DEVELOPMENT REVIEW BOARD
SUPPLEMENTAL SUBMITTAL

PROJECT NO. PR-2019-002277
Application No. SI-2019-00246

SUBMITTAL DESCRIPTION: DRB Site Plan Resubmittal.

**RE: Adagio Apartments
PR-2019-002277**

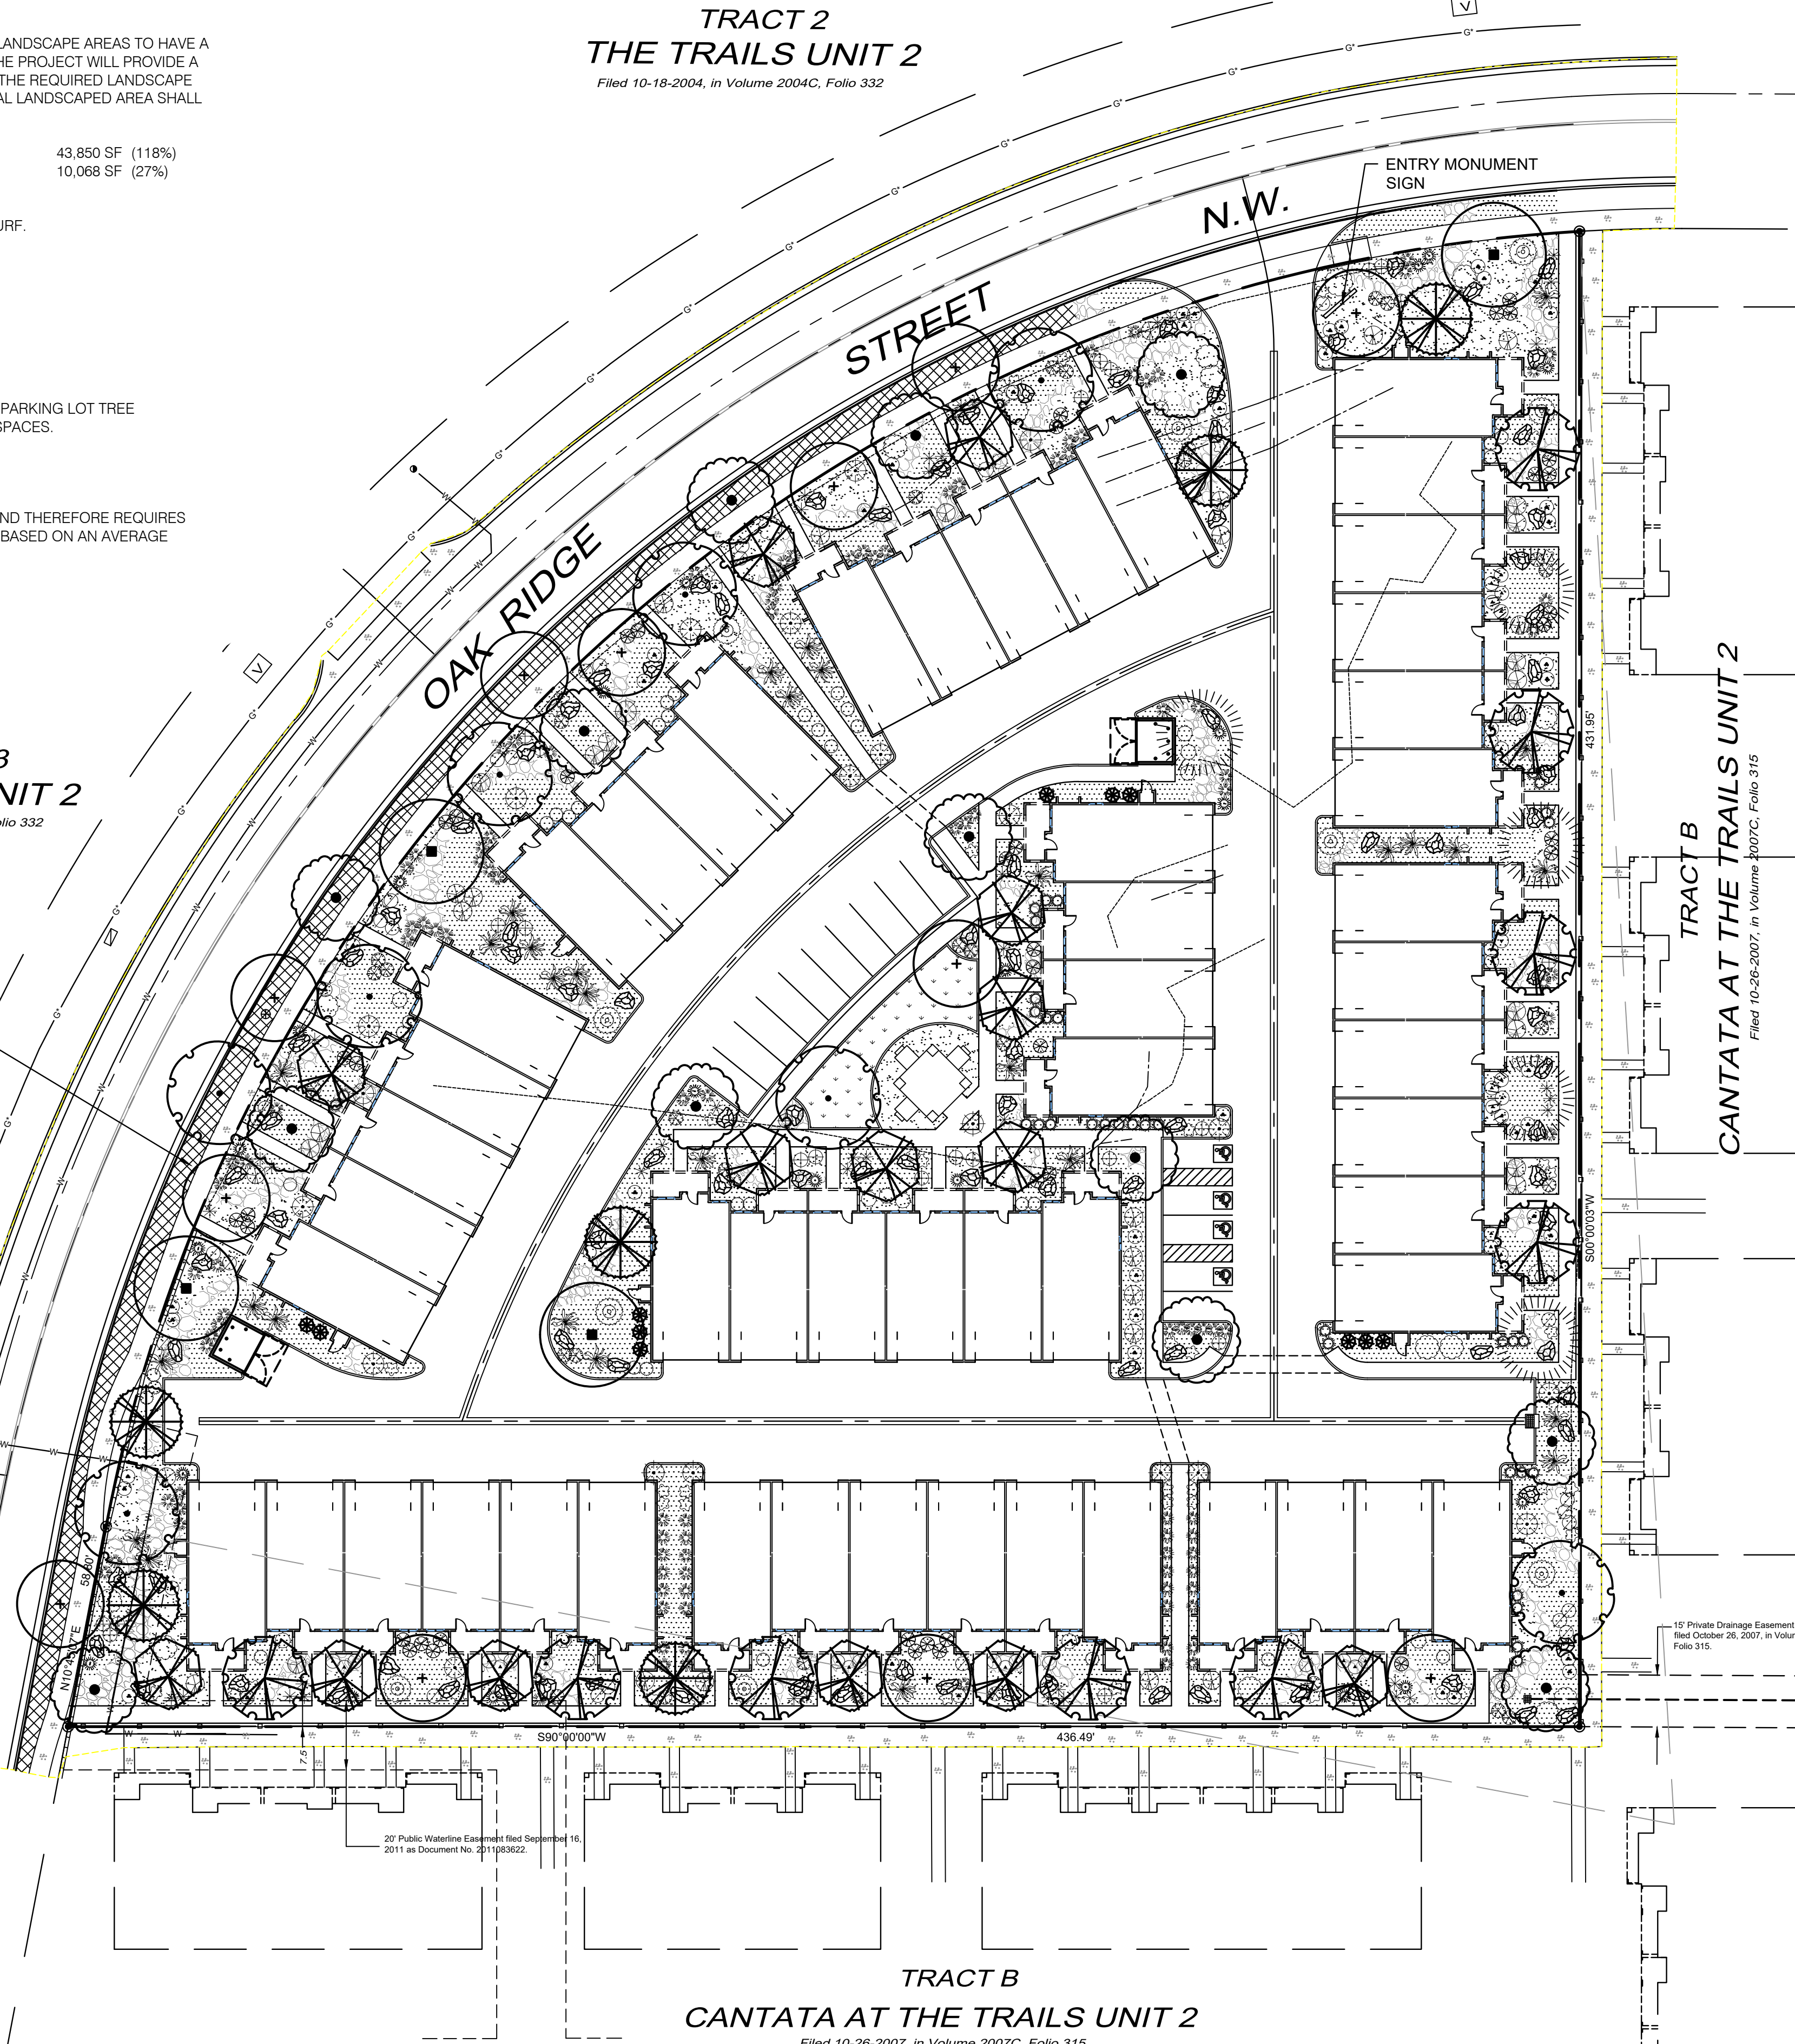
- / Landscape Plan
 - o There is proposed landscaping along the existing waterline near the southwest corner of the subject development. Please confirm trees will not be installed along the existing waterline easement.
 - *Response: Trees will not be installed within the existing waterline easement. See landscape plan attached.*
- / For information only.
 - o The development agreement was approved by the Water Authority Board and has been executed.
 - *Response: Acknowledged.*
 - o Revisions to the development agreement require board approval.
 - *Response: Acknowledged.*

PROJECT NAME: ADAGIO APARTMENTS  
SHEET TITLE: SITE PLAN  
DRB SITE PLAN  
SHEET NUMBER: C-100

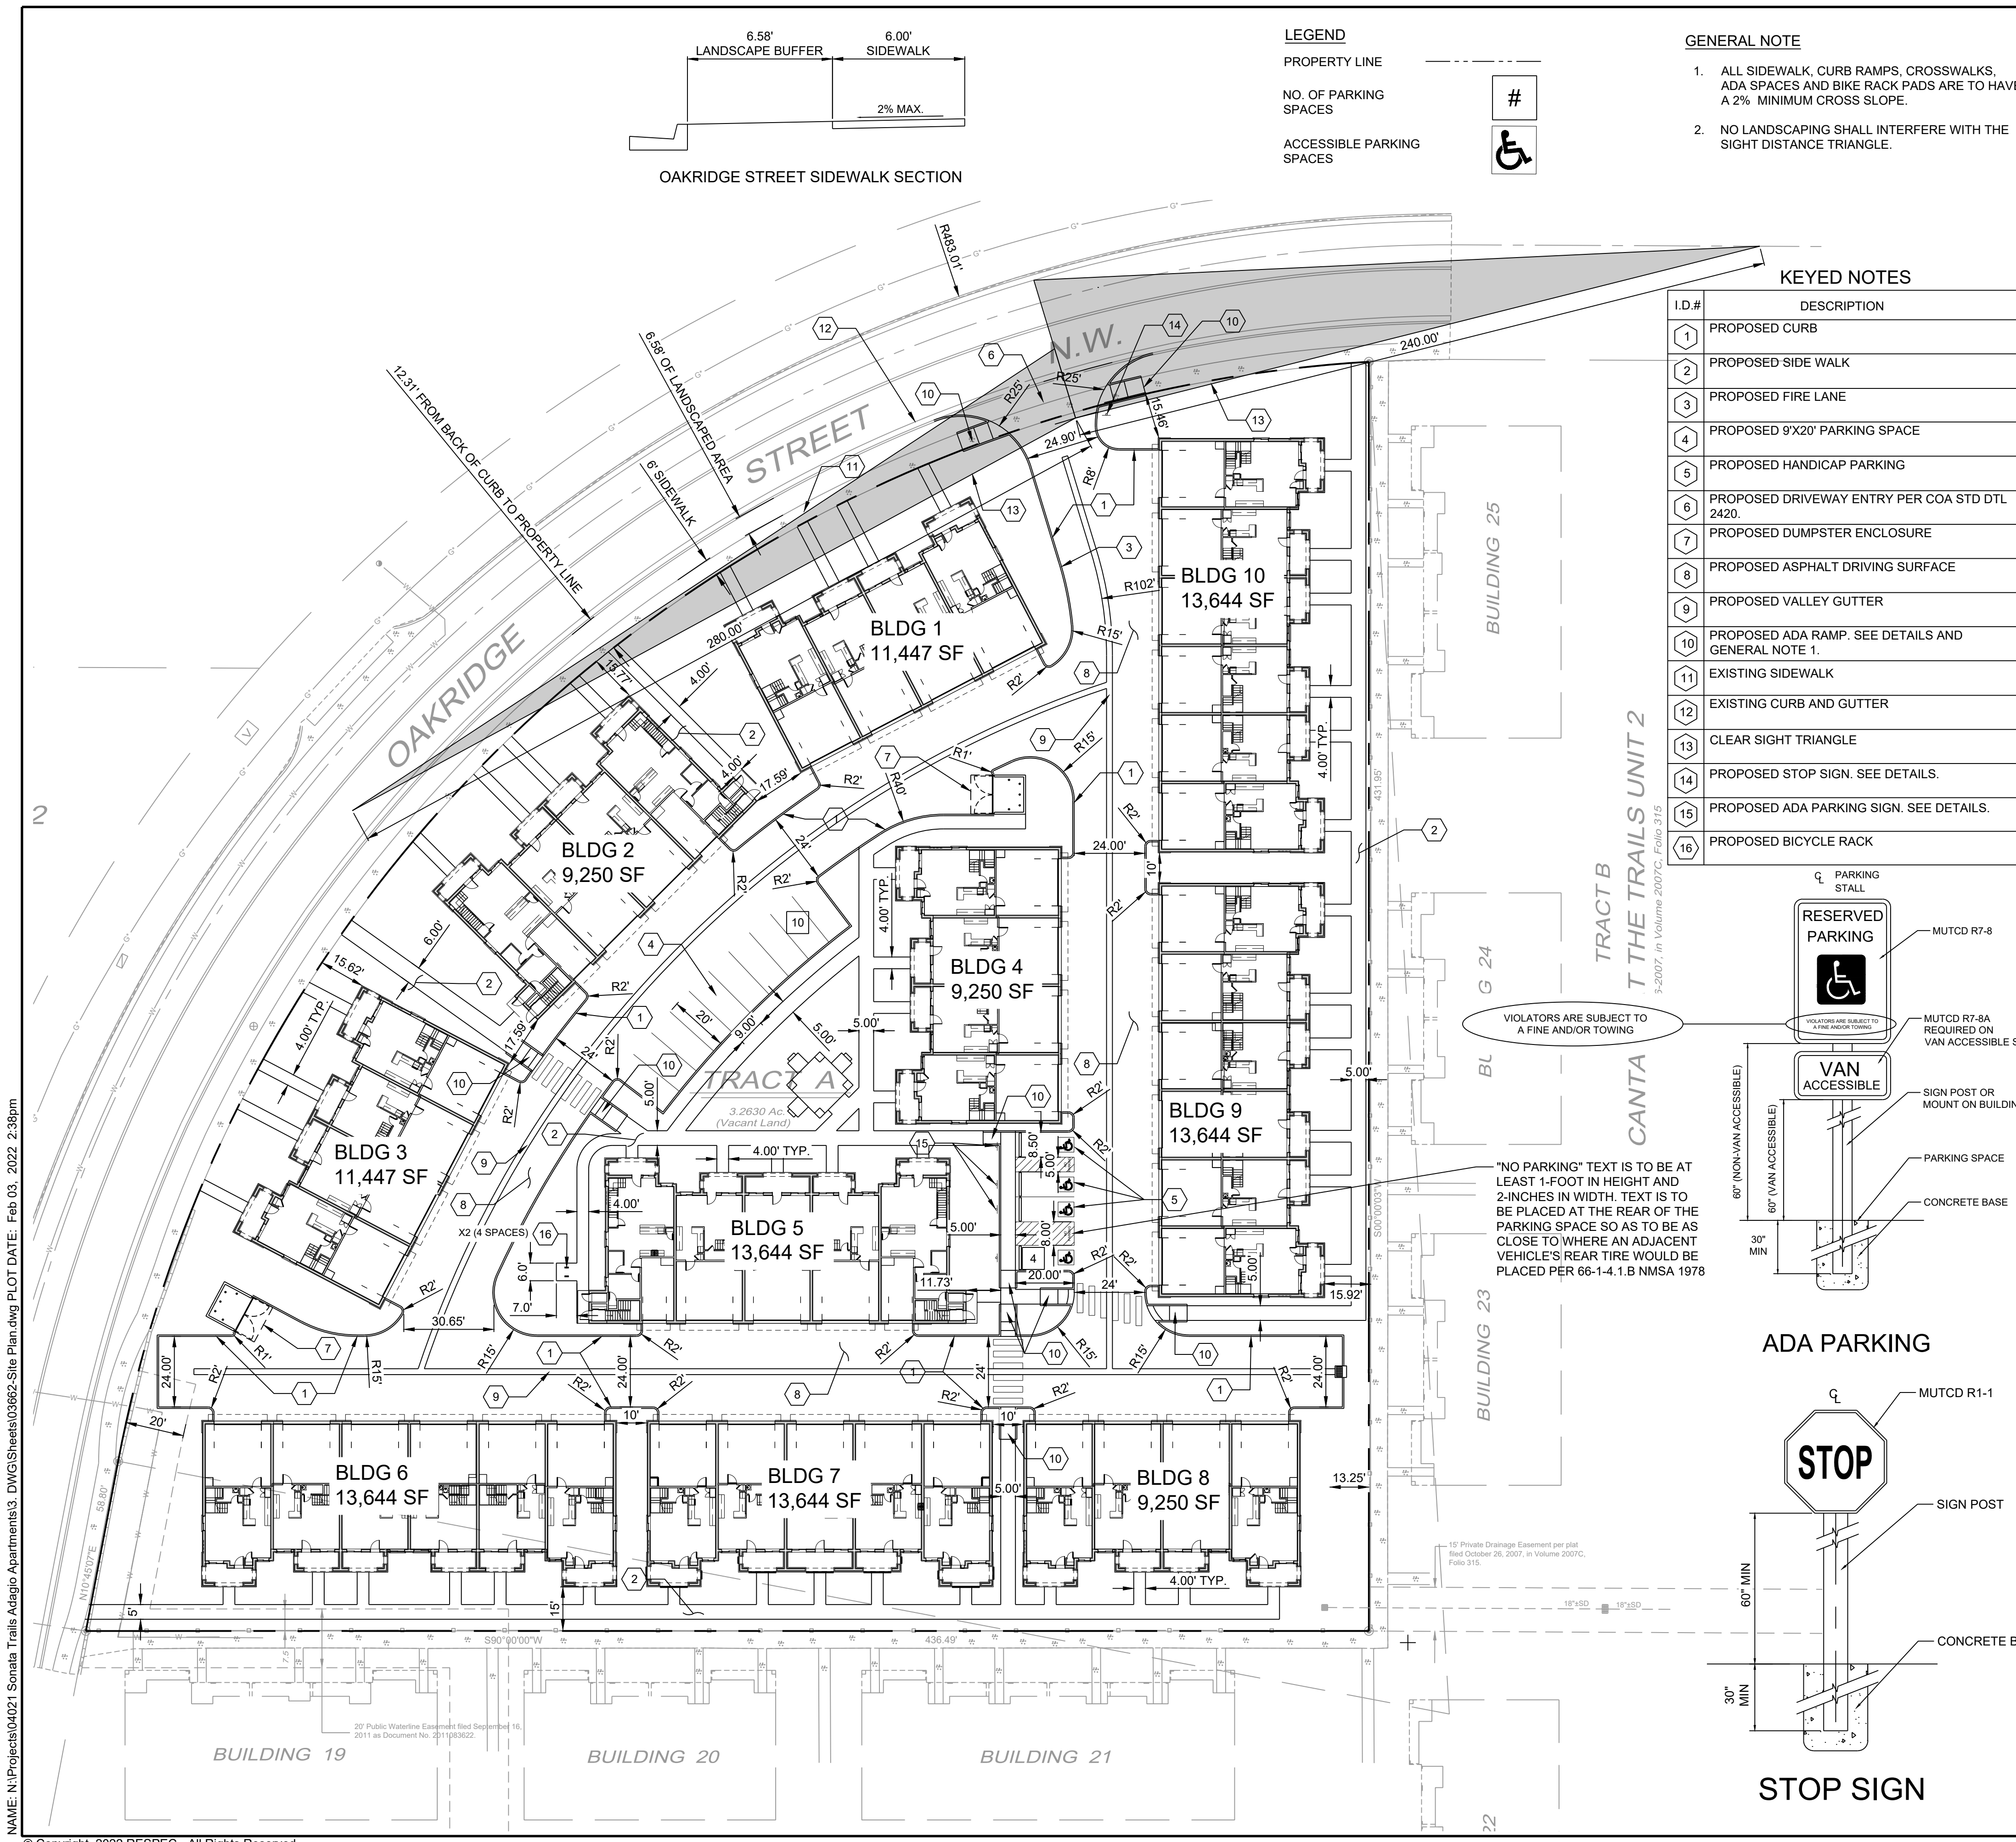
- / Provide a sidewalk exhibit for Oakridge Street showing the width of sidewalk and landscape buffer as well as the distance from back of curb to the property line.

- o *Response: A detail has been provided on the attached site plan.*
- / List number of multi-housing units on plan. With the parking calculations, include bicycle parking and handicapped space calculations.

- o *Response: See general note 1 on the revised site plan attached.*
- / Use keyed notes and graphics on the site plan to show curb ramp locations and bicycle parking space calculations.

- / It is not apparent what type of pavement surface is being proposed. A hard driving surface will be required as part of this proposed project for parking area and drive aisles.

- / The ADA accessible parking sign must have the required language per 66-7-352.4C NMSA 1978 "**Violators Are Subject to a Fine and/or Towing.**" This wording should be more visible on the plan. (Please call out detail and location of signs on the plans.)

- o *Response: See revised site plan attached including keyed notes to show curb ramps. A bicycle parking location still needs to be determined and will be showed and called out in a subsequent submittal.*

- o *Response: Asphalt pavement is being proposed. See keyed note 8 on the attached site plan.*
- / Has the Fire Marshall approved the plan? It is advisable to have a second emergency access. (It appears that second entrance could be accessed off of Oakridge with a new ADA-accessible drivepad.

- o *Response: This detail is provided on the attached site plan.*
- / The ADA access aisles shall have the words "**NO PARKING**" in capital letters, each of which shall be at least one foot high and at least two inches wide, placed at the rear of the parking space so as to be close to where an adjacent vehicle's rear tire would be placed. (66-1-4.1.B NMSA 1978). This should be clearly called out on a note or a detail.

- o *Response: This detail is provided on the attached site plan.*

PROJECT NAME:	ADAGIO APARTMENTS	
SHEET TITLE:	DETAILS	
SUBMITTED FOR:	DRB DETAILS	
SHEET NUMBER:	C-500

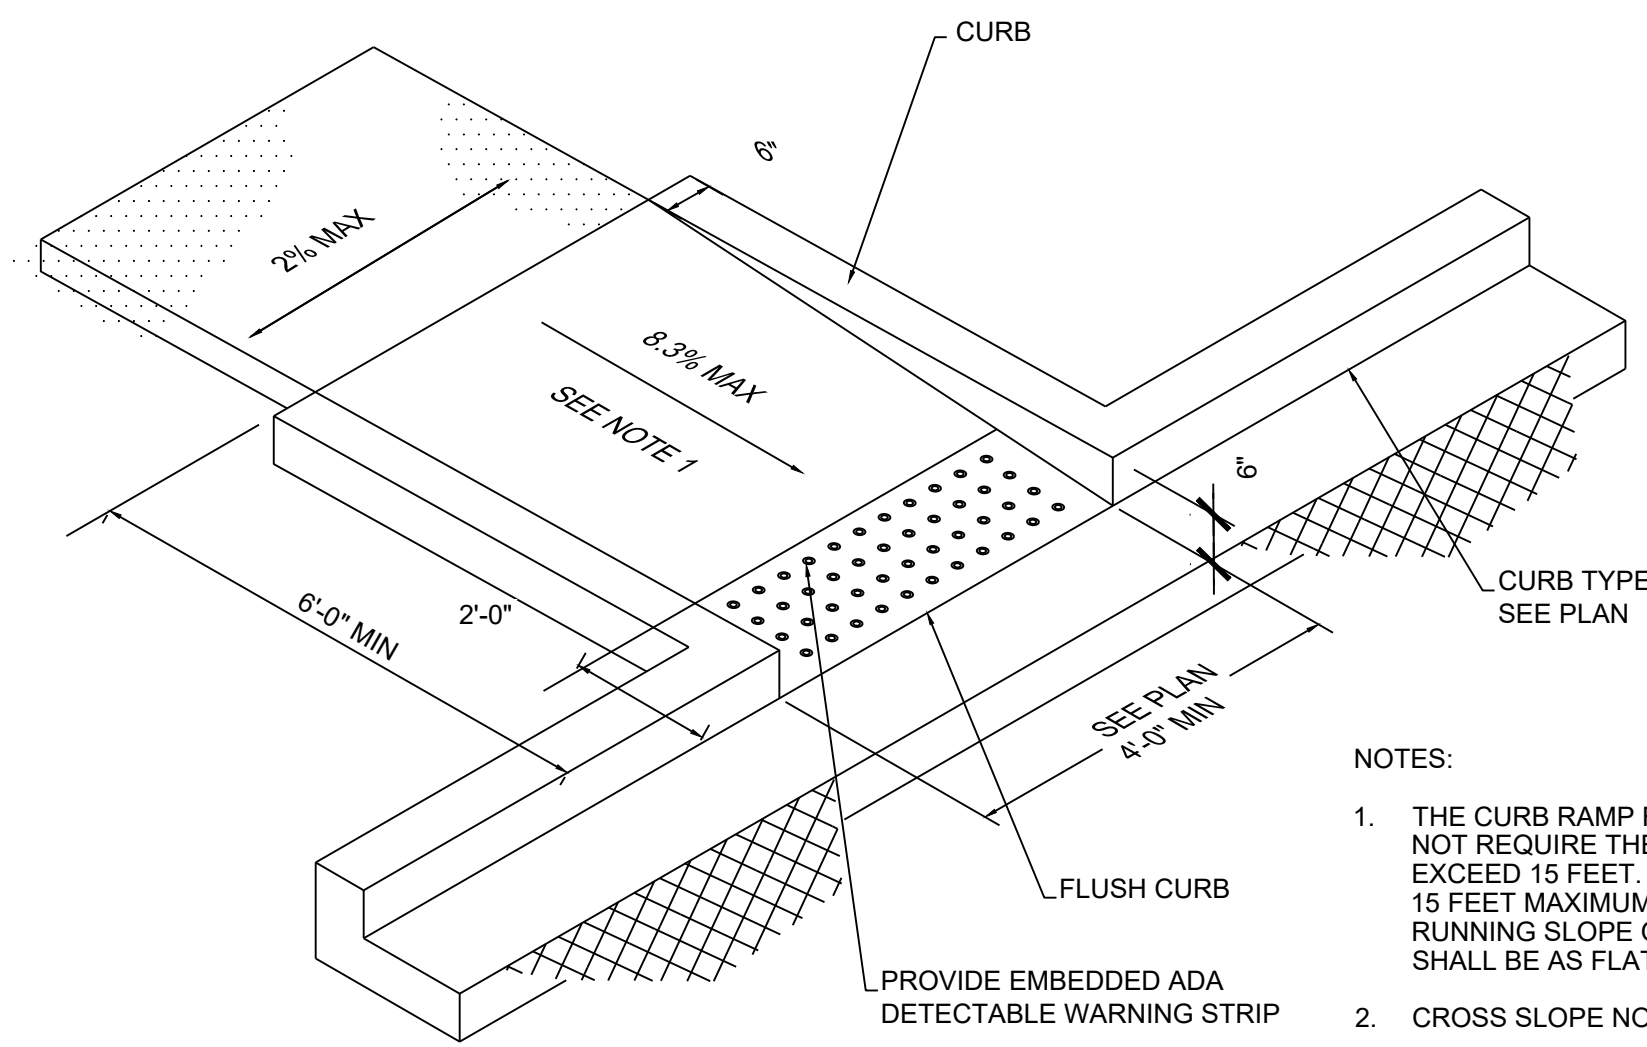
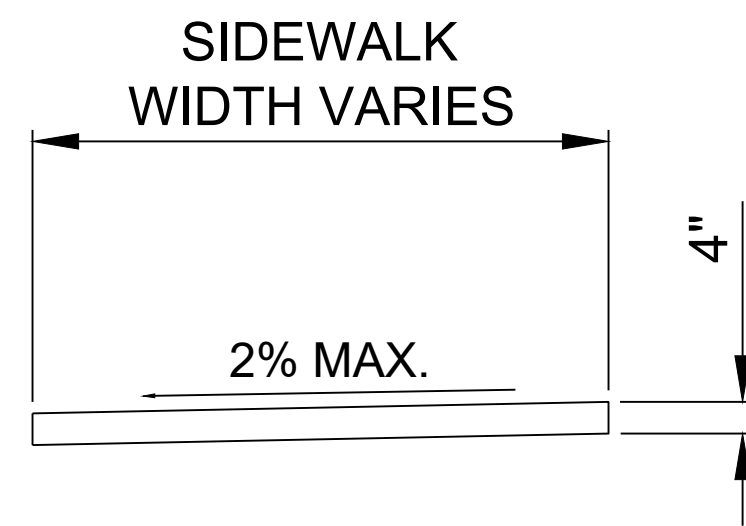
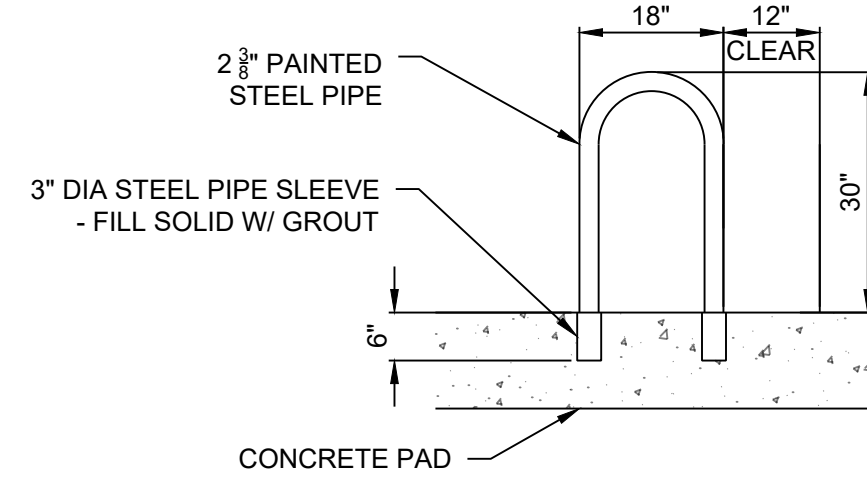
- o *Response: The revised site plan attached includes parking calculations including bicycle parking and ADA spaces.*
- / Provide more detail at the entrance with regard to ADA accessibility, and provide civil details showing with additional curb ramp details as needed, sidewalk details showing 2% maximum sidewalk cross-slopes, crosswalks, handicapped parking spot details, bike rack details, etc. (Follow IDO/DPM guidelines on needed bike rack details.)
